April 29, 2022

I received the intake screening correction notice for project #2204-105 (4124 83<sup>rd</sup> Ave SE) dated April 27, 2022. Below are the requested corrections and locations on the drawings where they can be found:

H2D Architecture + Design

SITE PLAN

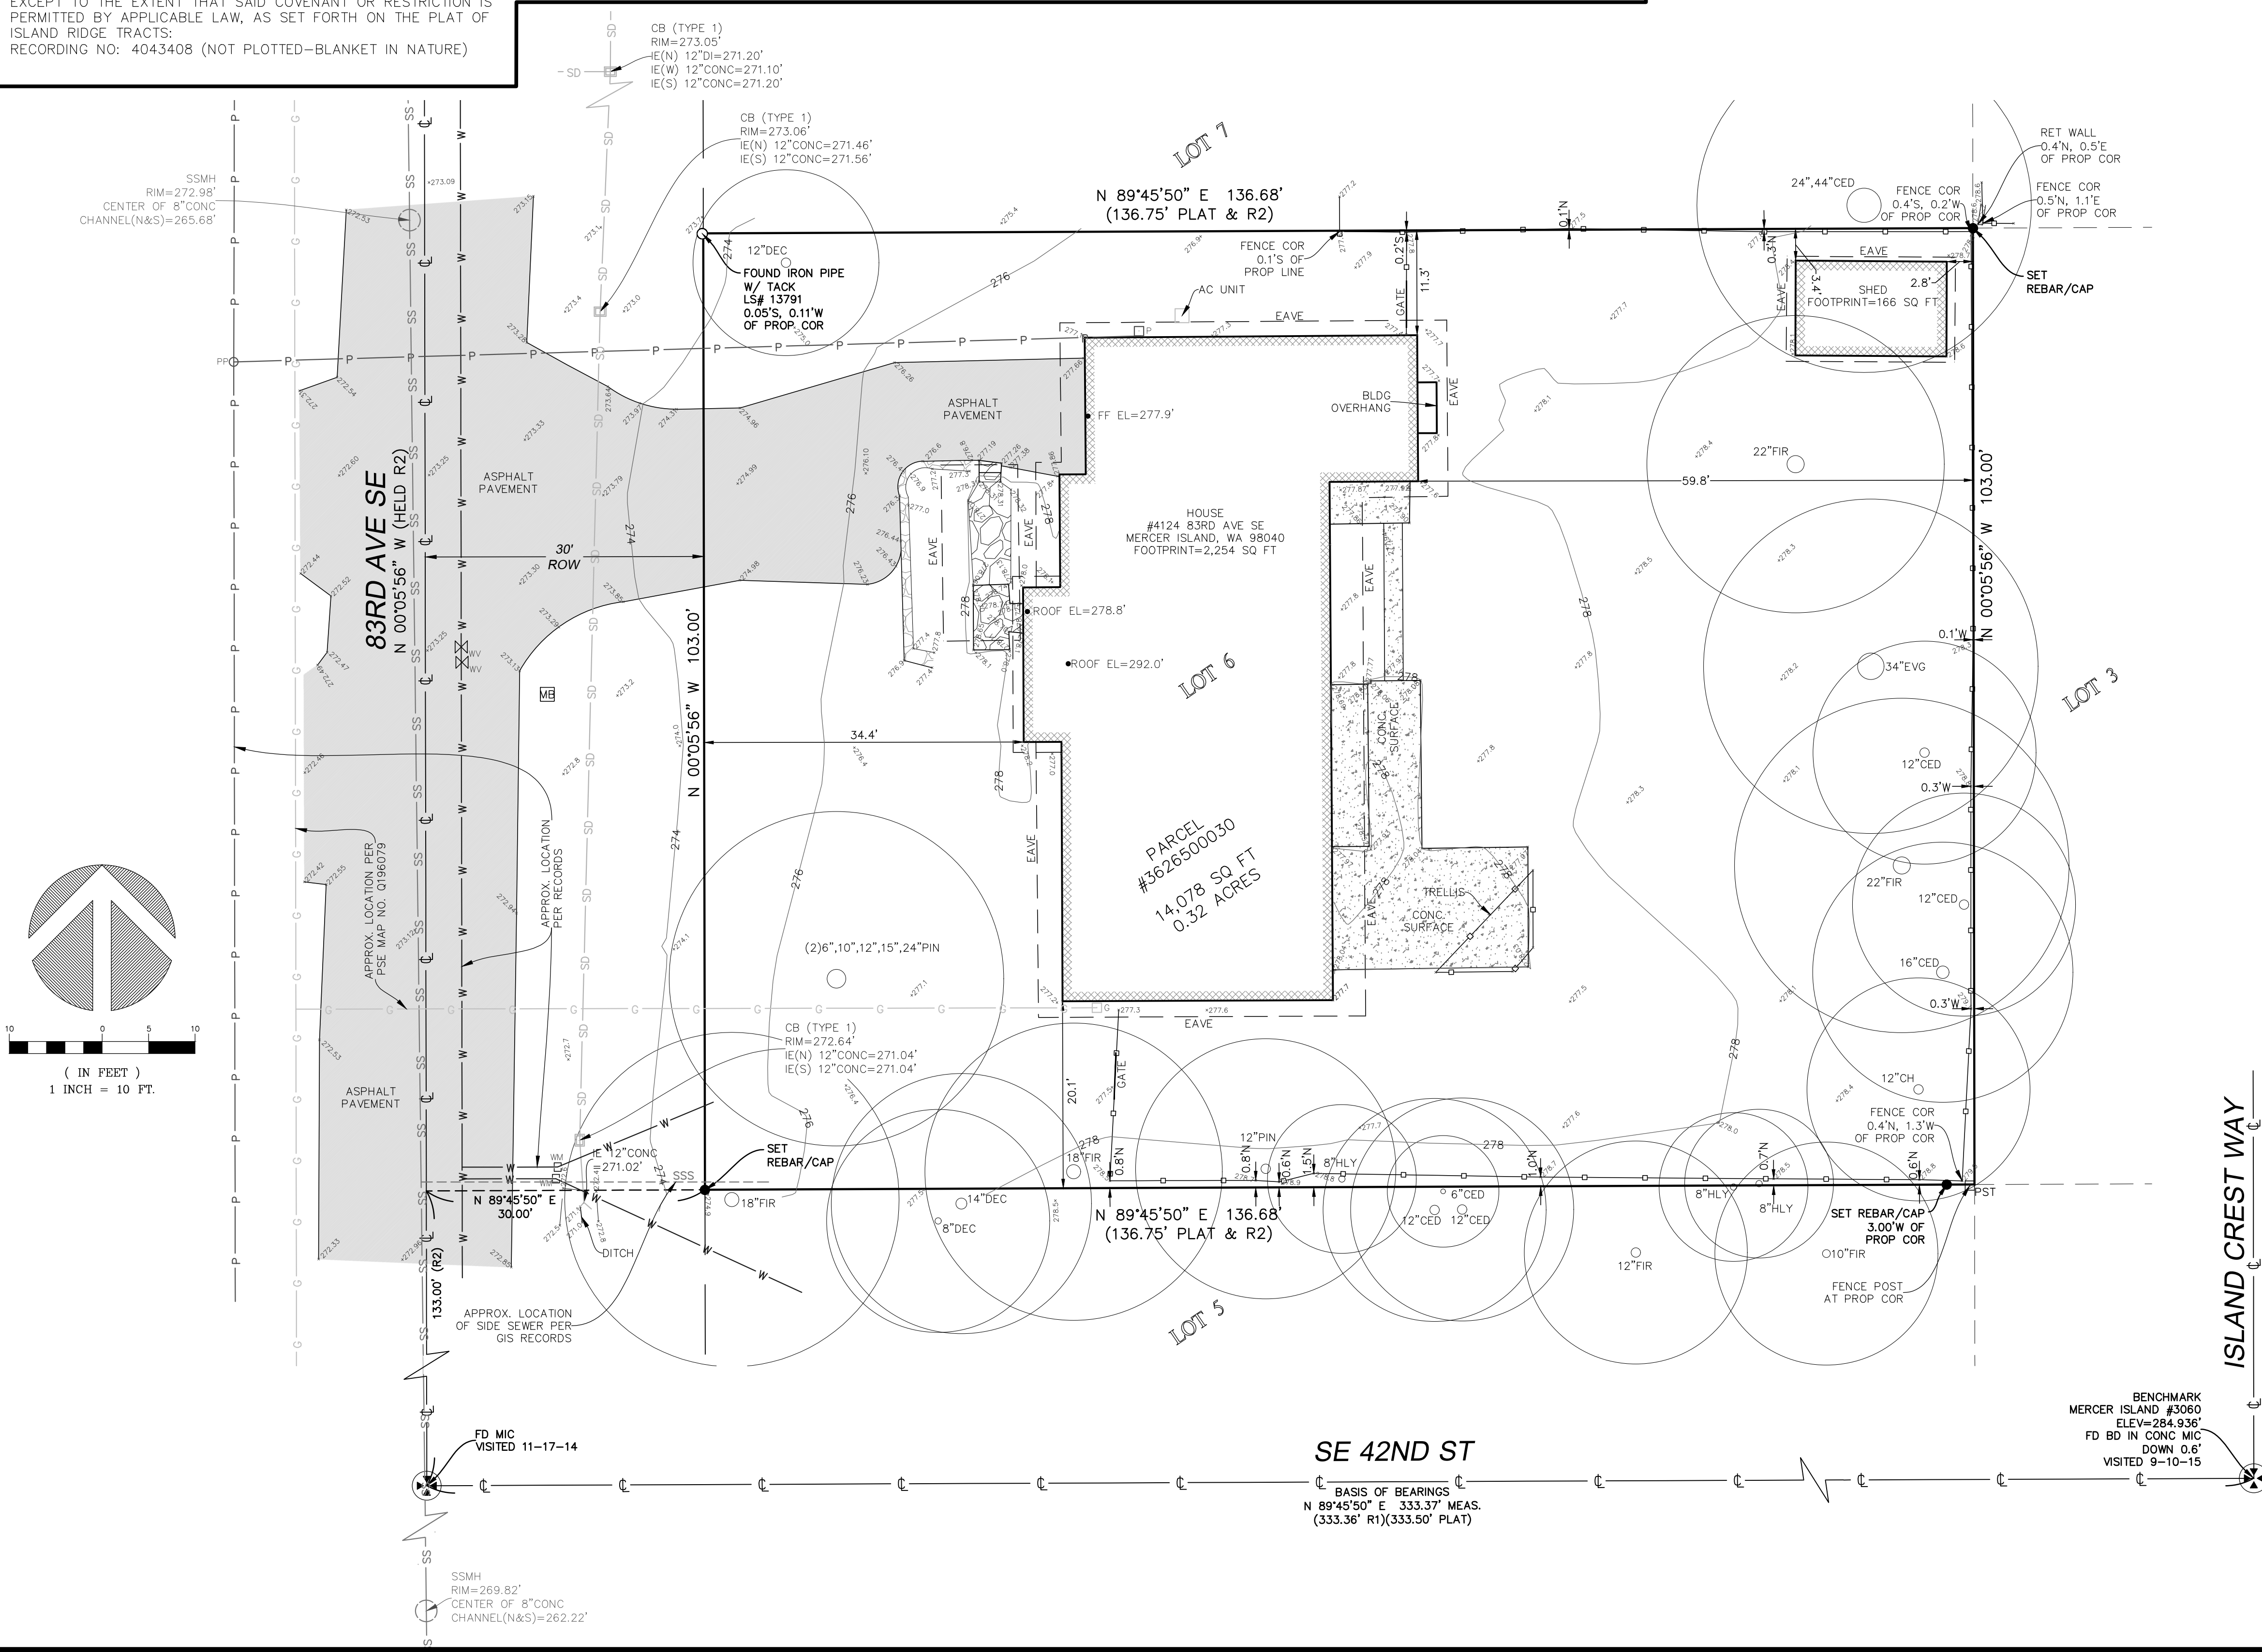
1. Water Supply Meter and Supply line sizes have been noted on Site Plan. Refer to 02 Sheet.

1. Lot Coverage and Hardscape calculations have been coordinated between Architectural and Landscape Plans. Refer to 02 Sheet. The site development worksheet has been updated to coordinate with the architectural and structural plans.
2. Grass strips between concrete at driveway has been added to driveway lot coverage calculation.

GRADING AND UTILITY PLAN

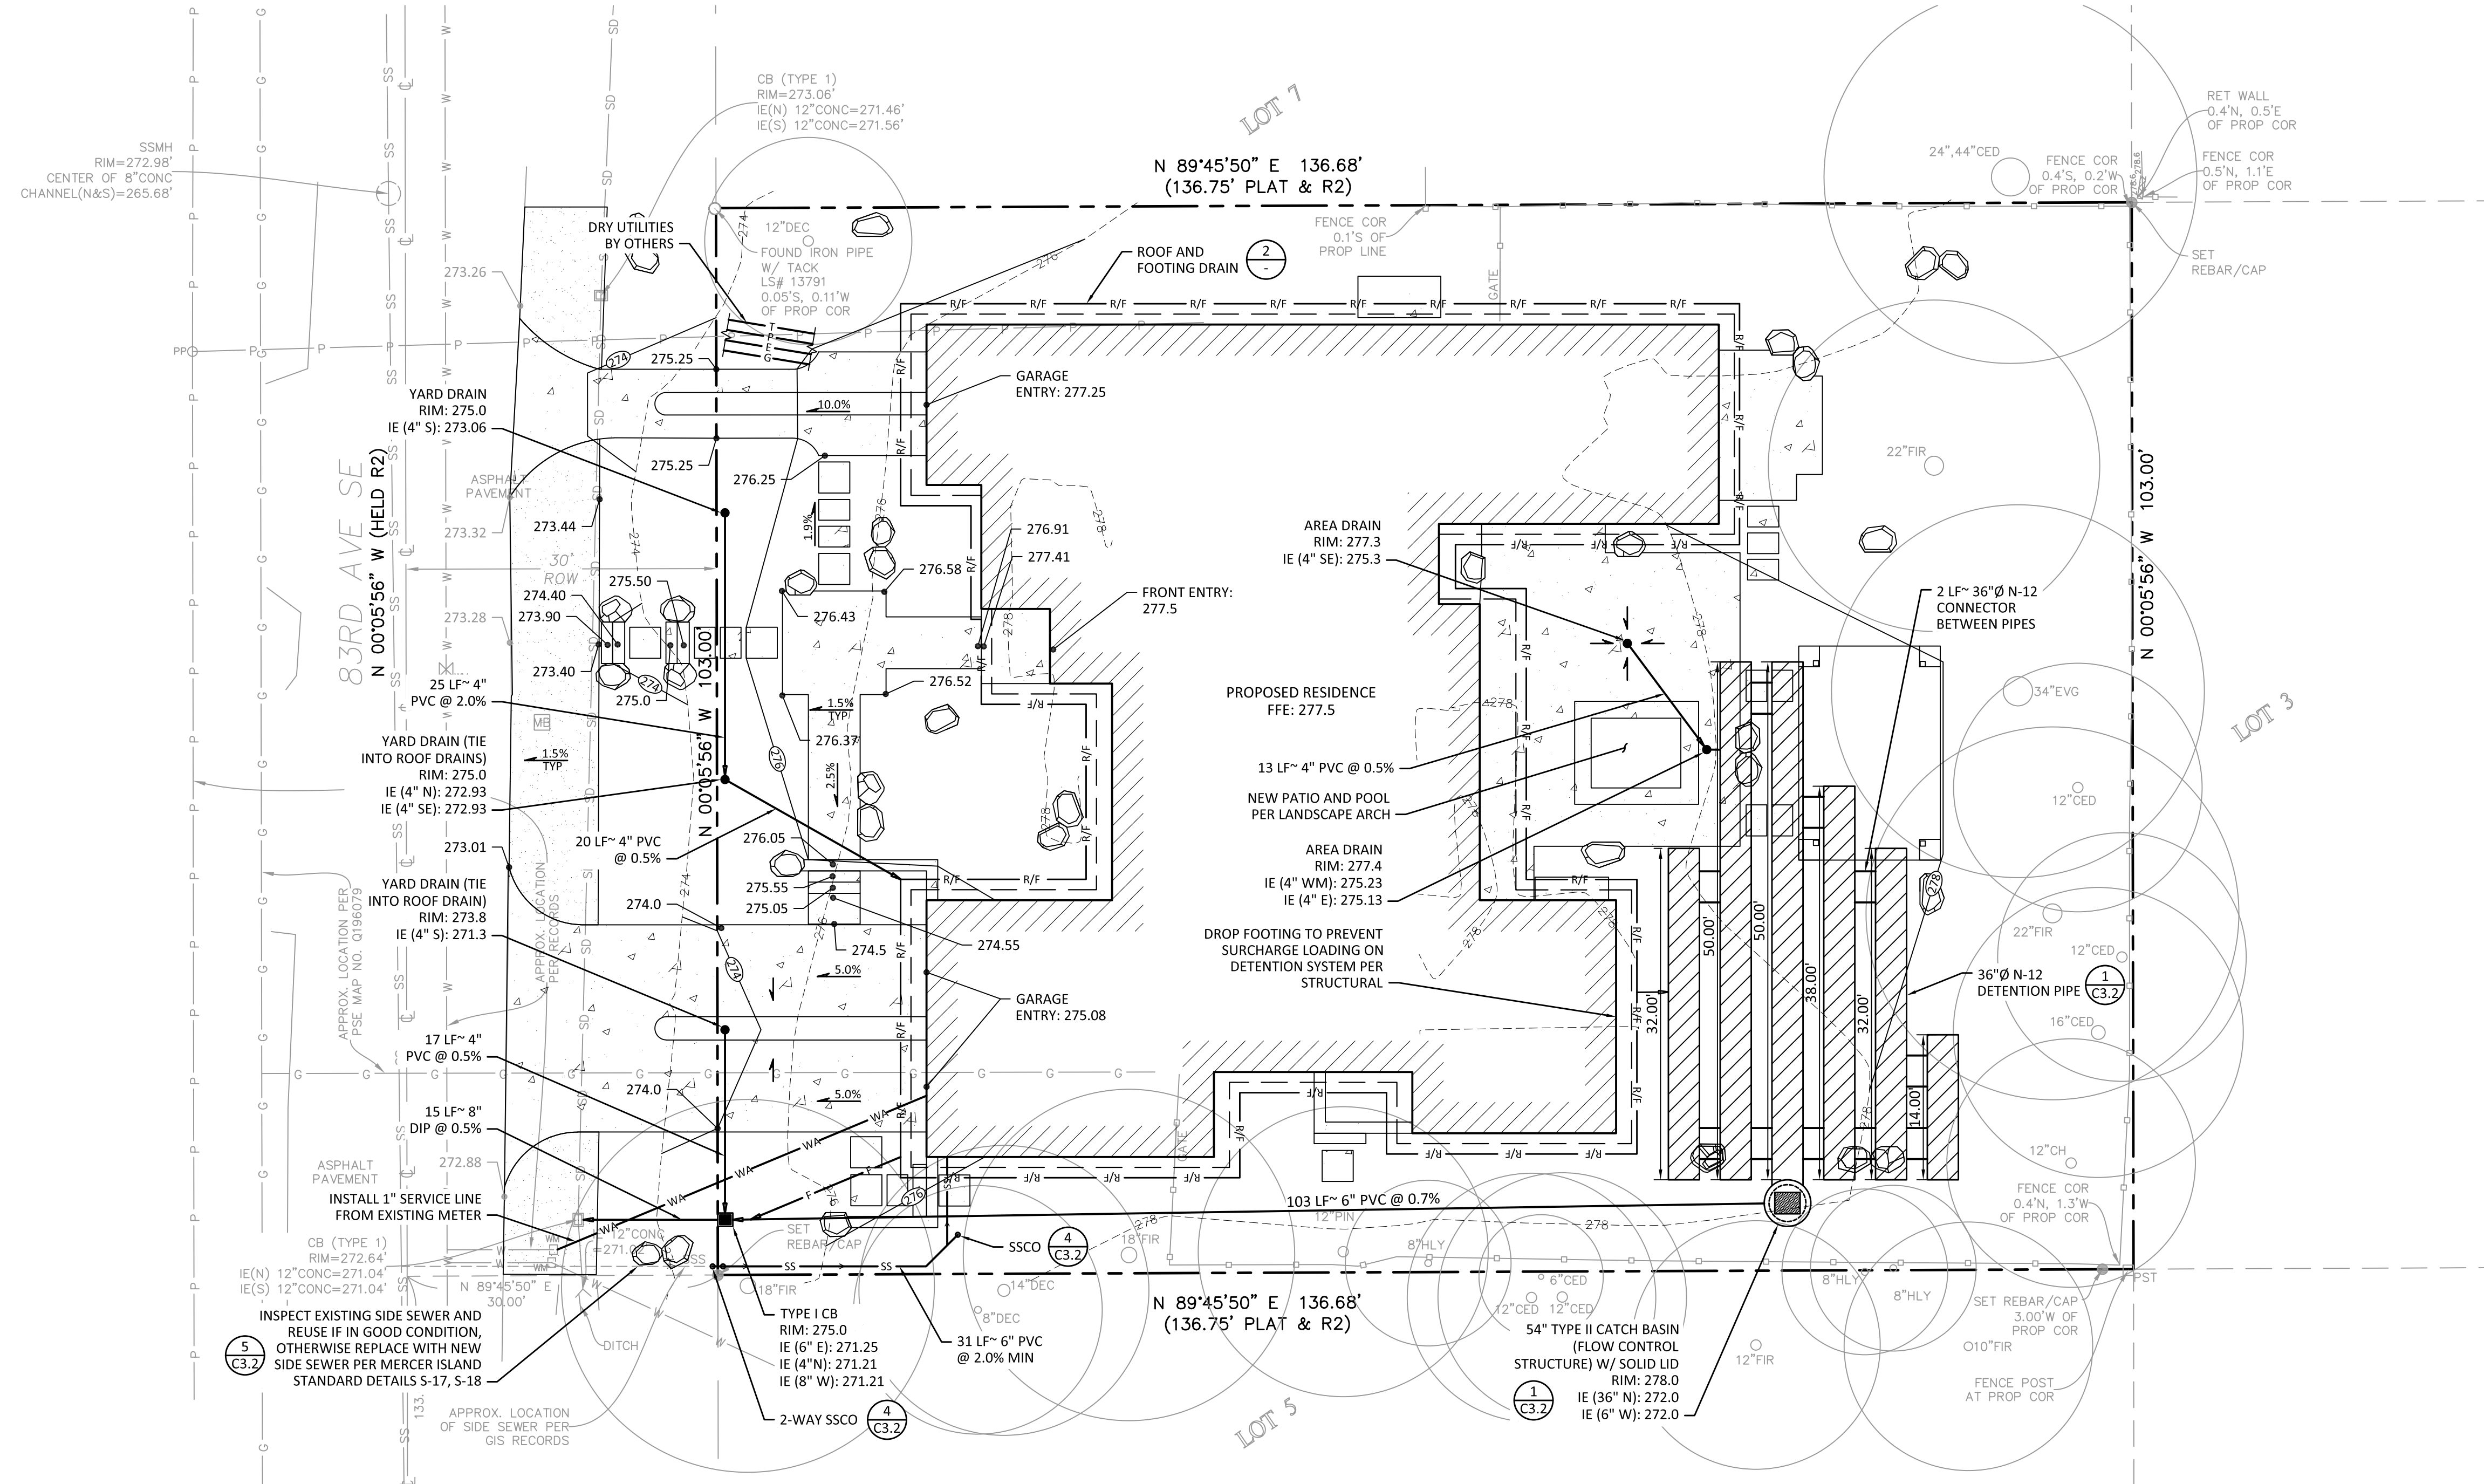
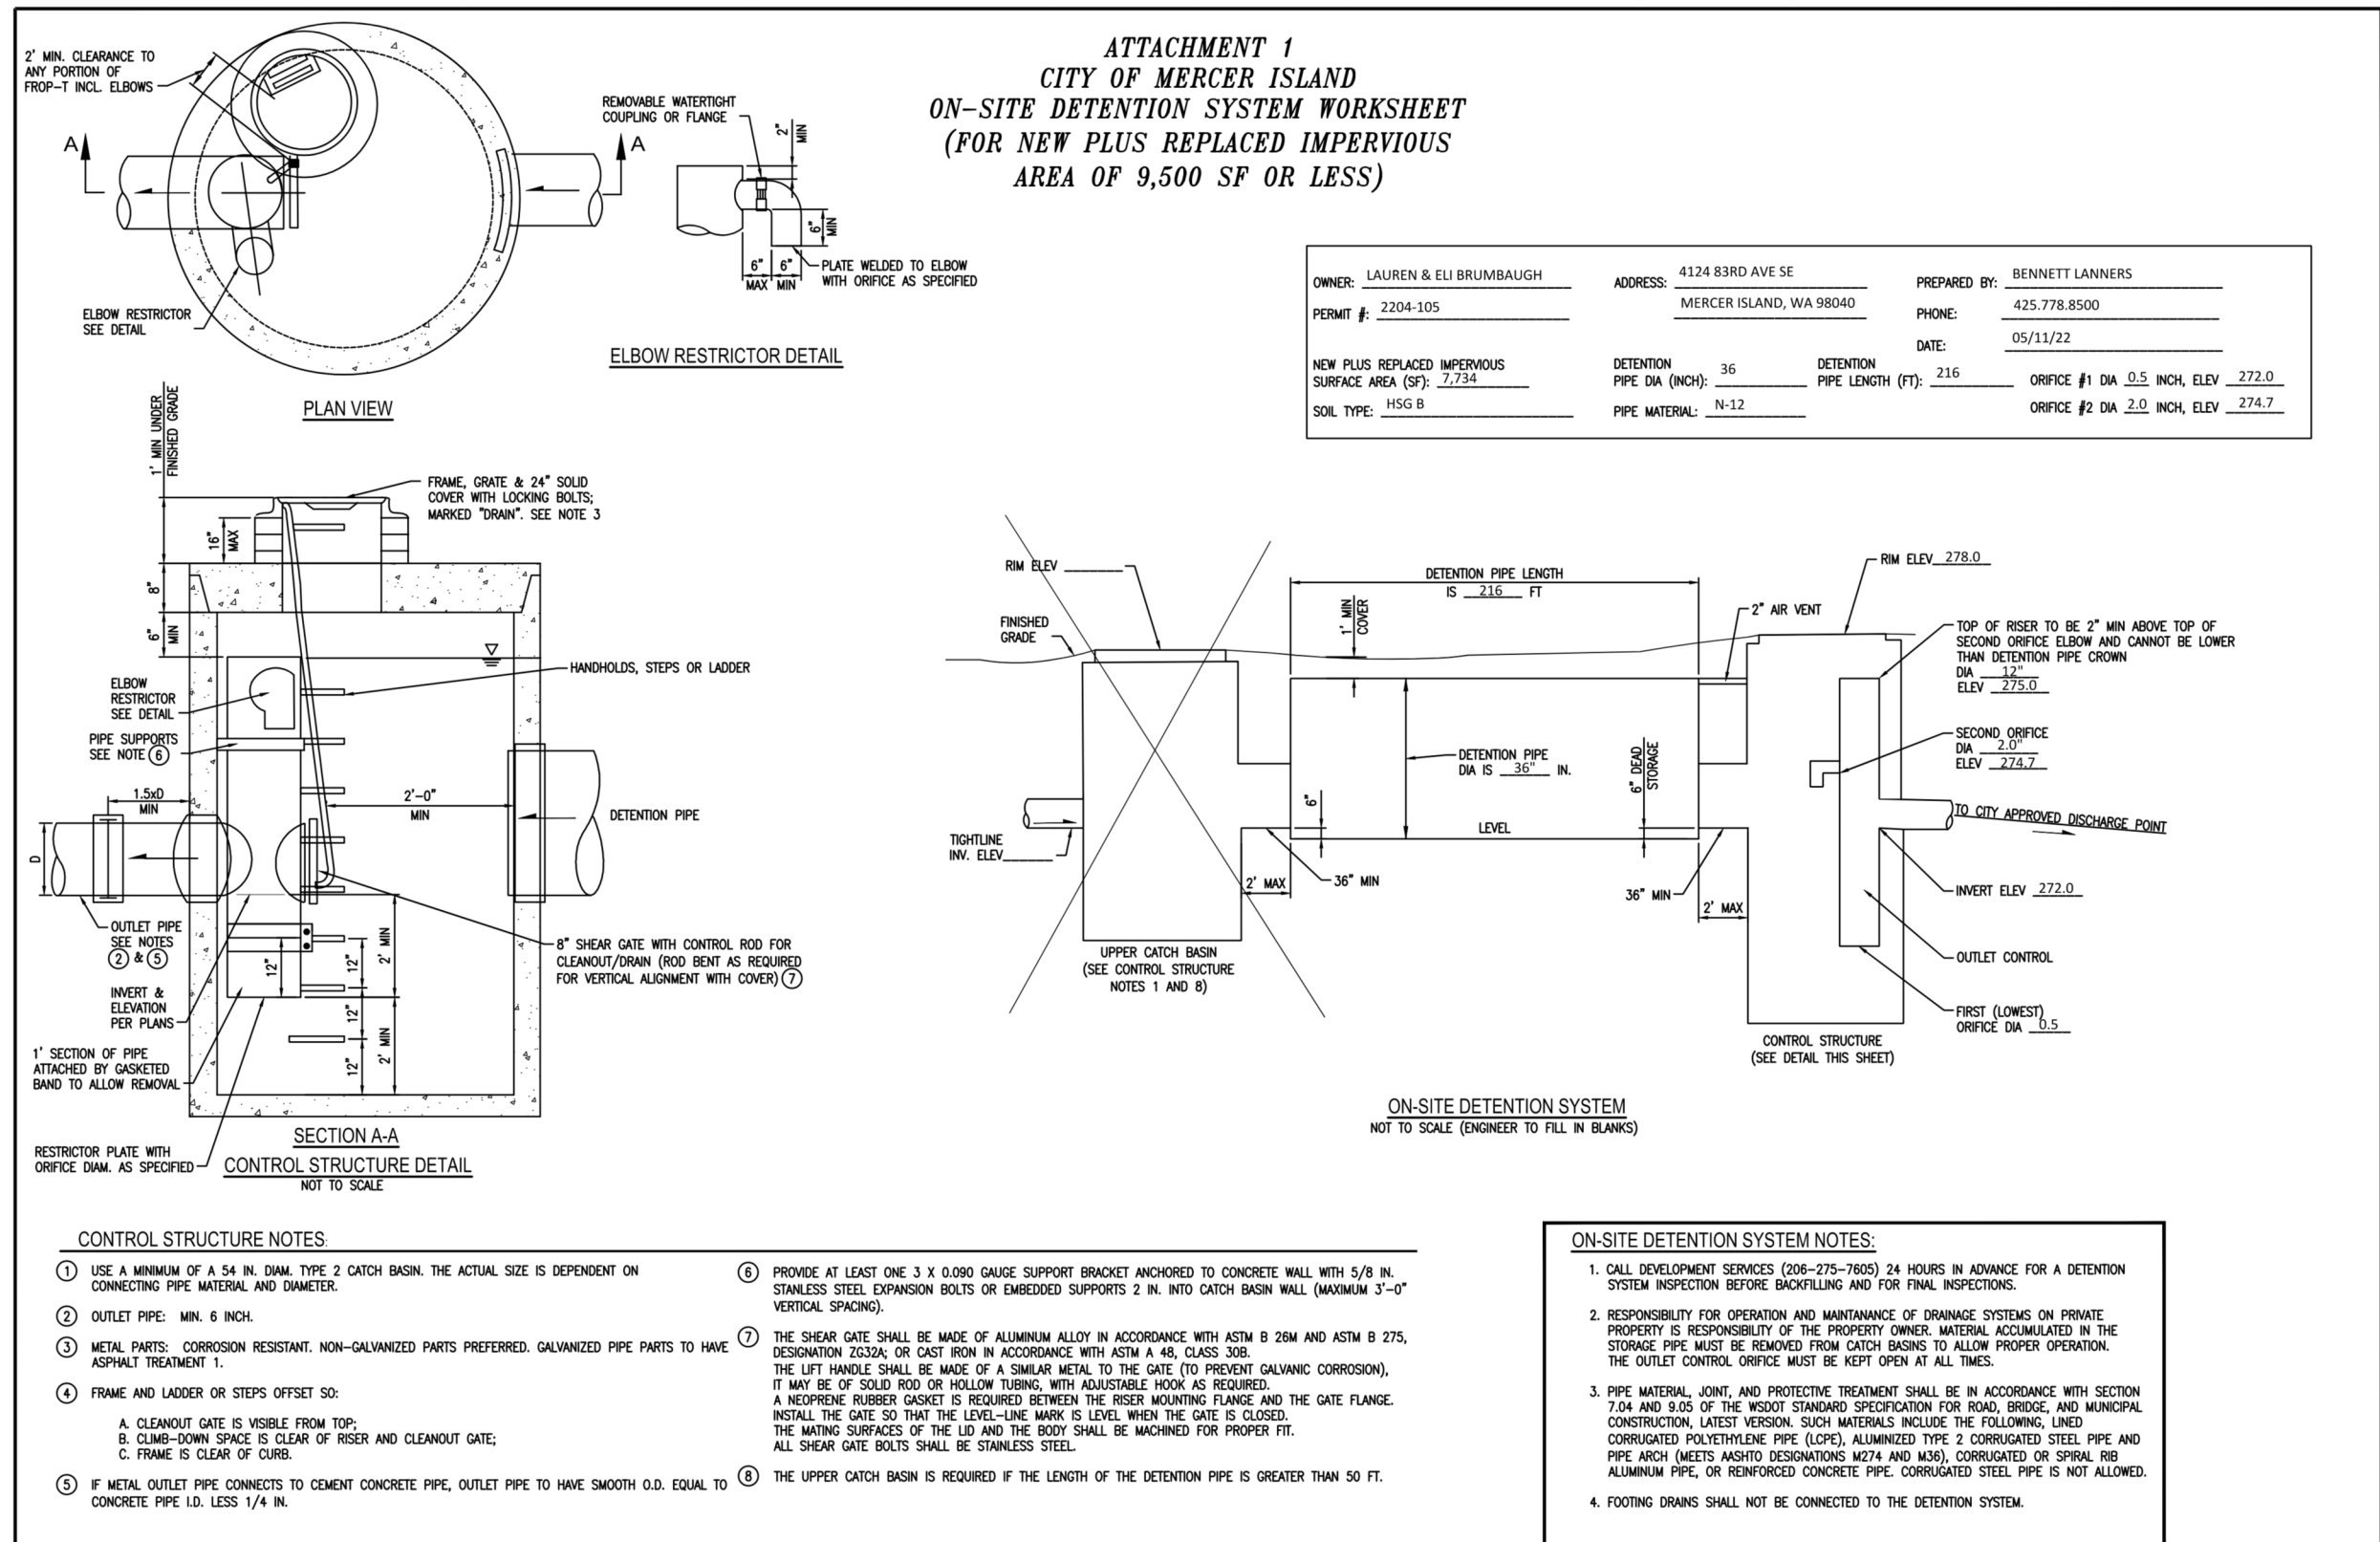
1. Arborist Report has been included in resubmittal.
2. Tree Inventory has been included in resubmittal.
3. The detention system has been relocated to minimize impact on the trees. Refer to the C-sheets.
4. Additional Arborist addendum has been included in resubmittal to reference re-submitted plan set date.
